Address: 52 Daisy Lea Lane Huddersfield HD3 3LL

Application number: 2023/90747	
What is the application for?:	Variation of condition 2 (plans and specifications) on previous permission (2021
Address of the site or building:	5, Southway, Lindley, Huddersfield, HD3 3LN
Postcode:	HD3 3LN

8. Proposed East Elevation (Front)
Scale 1:100

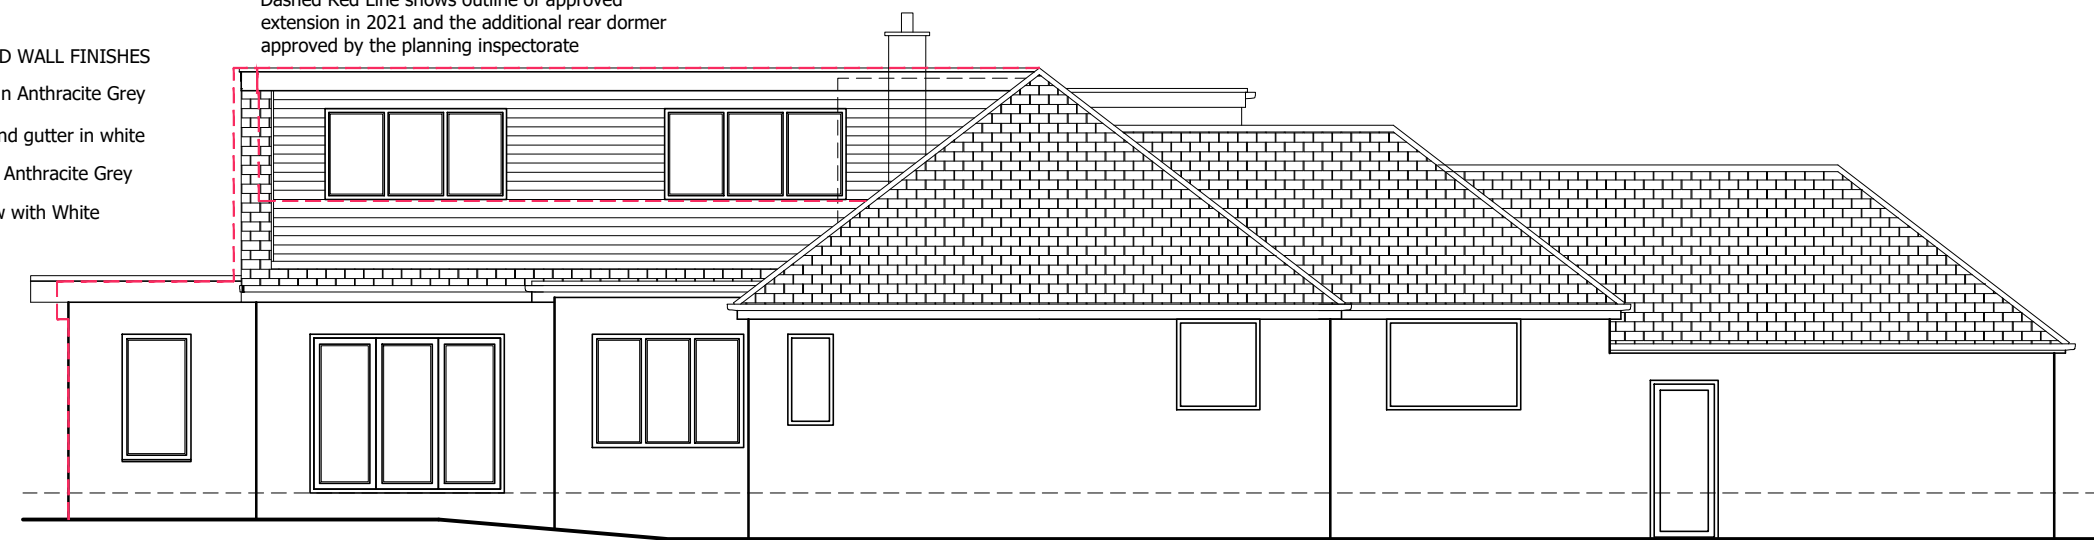
Due to the use of large and white soffits, fascias, and eaves to the dormers, the height of the property is altered with respect to the previous plans. In addition, the appearance is unsightly, detrimental, and out of character to the surrounding properties. This unapproved construction creates increased shadowing across the whole of my garden.

10. Proposed West Elevation (Rear)
Scale 1:100

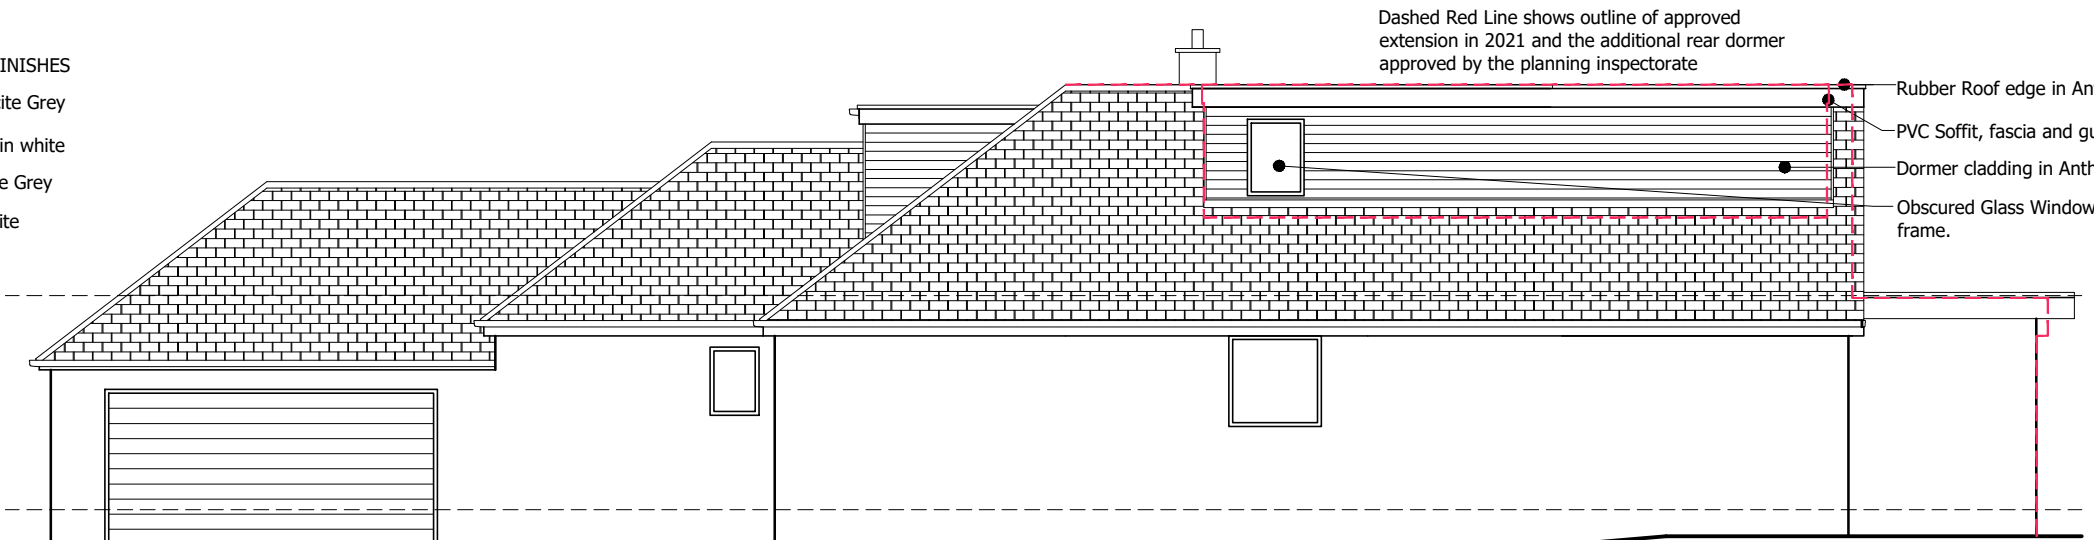
The dormer window in place opens directly not only on to the garden but into my bedrooms and living spaces within my property.
